# CITY OF ALBUQUERQUE

December 23, 2022

**Re: McDonald**  
**1901 Ladera Dr. NW**  
**Traffic Circulation Layout**  
Engineer's Stamp 11-23-22 (H09-D020)

Based upon the information provided in your submittal received 12-14-22, the above referenced plan cannot be approved for Building Permit until the following comments are addressed:

### C4.1 TRAFFIC CIRCULATION PLAN

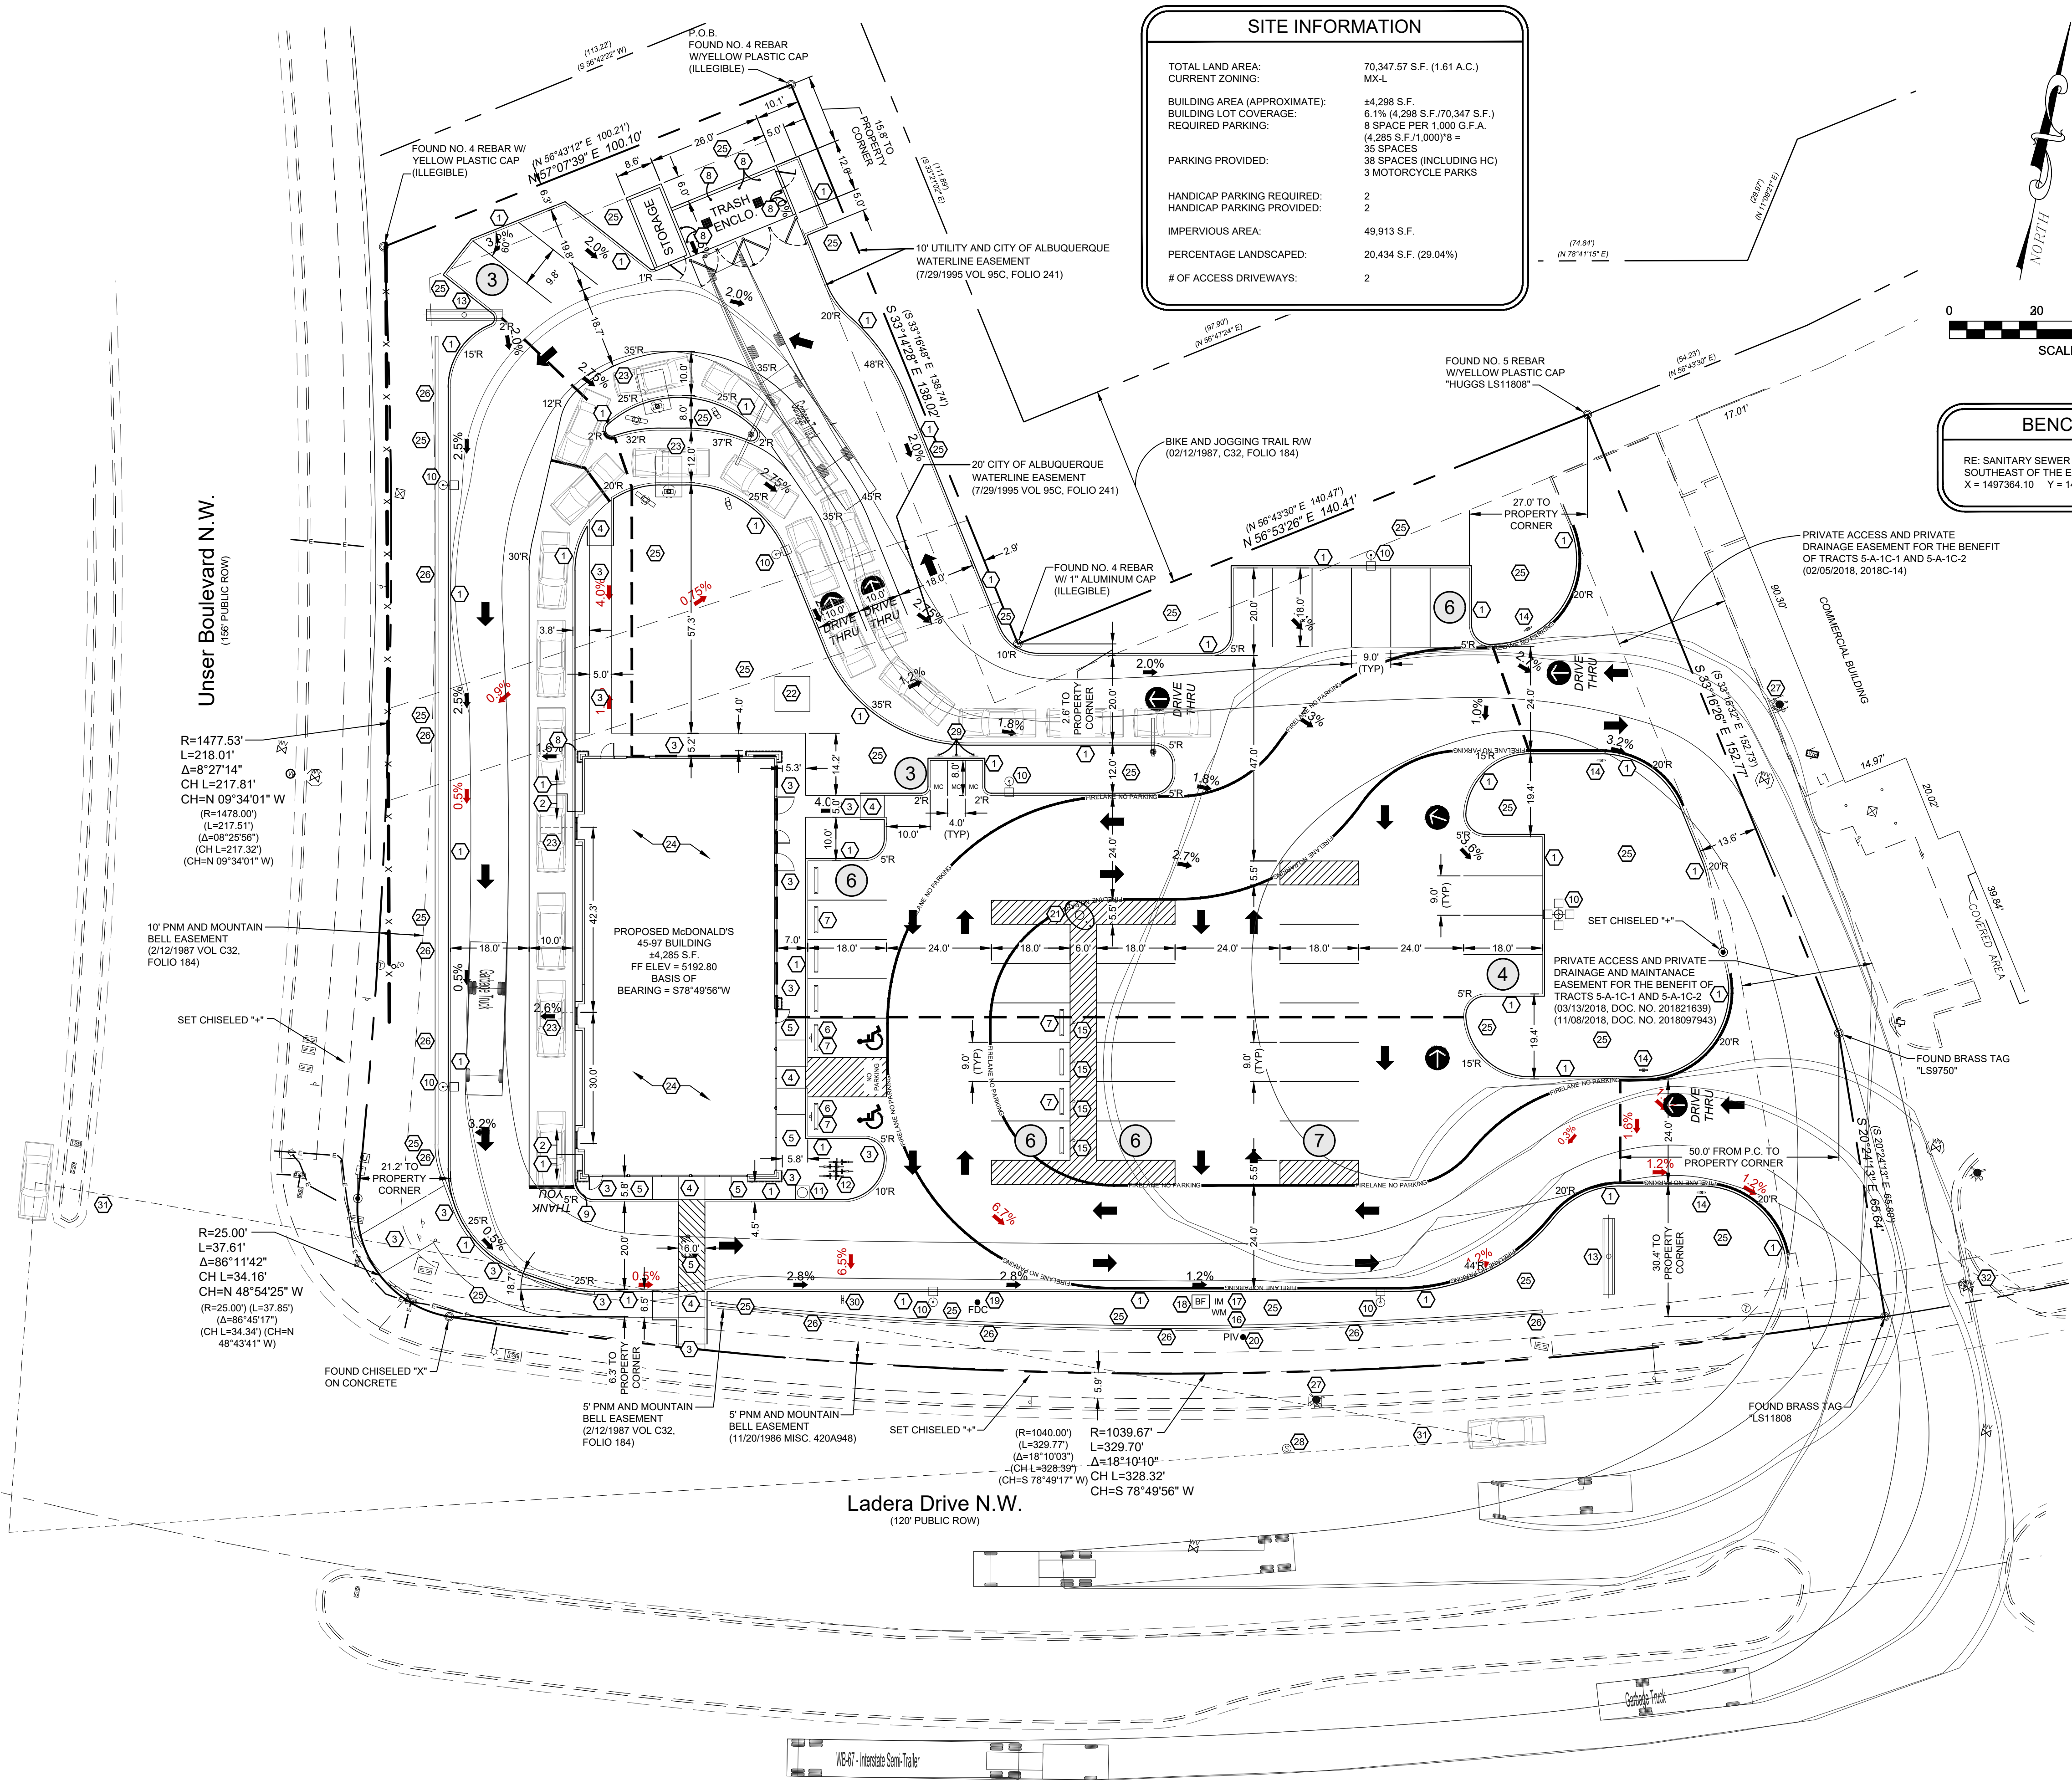
3. Key note 4: provide design details for the proposed ADA ramps, and add a note "the max. Slope for the landing area in all direction should not exceed 2%".

4. Provide details for all the proposed signs and pavement marking. Please provide face signs details.
5. Keynote 3: provide the width for the existing sidewalk.

6. Key note 12: provide details for the proposed bike rack.
7. Motorcycle parking spaces shall be designated by its own conspicuously posted upright sign, either free-standing or wall mounted per the zoning code.

8. The pavement marking "MC" should be shown in the opposite direction for motorcycles entering the parking space.
9. All bicycle racks shall be designed according to the following guidelines:

11. A 1-foot clear zone around the bicycle parking stall shall be provided.
12. Bicycle parking spaces shall be at least 6 feet long and 2 feet wide.
13. Show on the site plan the 6' wide ADA pathway from the public sidewalk to the building entrance.

14. Refuse vehicle maneuvering shall be contained on-site. The refuse vehicle shall not back into the public right of way. Provide a copy of refuse approval.

15. Provide a copy of Fire Marshal approval.
16. It is not apparent what type of pavement surface is being proposed. A hard driving surface will be required as part of this proposed project for parking area and drive aisles.

17. All one-way drives shall have "One Way" and "Do Not Enter" signage and pavement markings. Please show detail and location of posted signs and striping. Please provide "DO NOT ENTER" sign and pavement marking at the exit of the one way drive aisle at the Southside of the building. And provide a "STOP" sign too.

18. The minimum drive through lane width is 12 feet with a 25 foot minimum radius (inside edge) for all turns. (A 15 foot radius can be used with an increase in lane width to 14 feet). Please dimension all lane widths and radii. 10 ft. wide drive lane is not acceptable.

19. Show the clear Intersection sight triangle at the driveway access off Ladera Dr. and on the intersection of Ladera Dr. and Unser Blvd. and add the following note to the plan: "Landscaping and signage will not interfere with clear sight requirements. Therefore, signs, walls, trees, and shrubbery between 3 and 8 feet tall (as measured from the gutter pan) will not be acceptable in the clear sight triangle. See attached Intersection sight triangle requirements.

20. Please specify the City Standard Drawing Number when applicable.
21. Add a note stating "All broken or cracked sidewalk must be replaced with sidewalk and curb & gutter." A build note must be provided referring to the appropriate City Standard drawing.
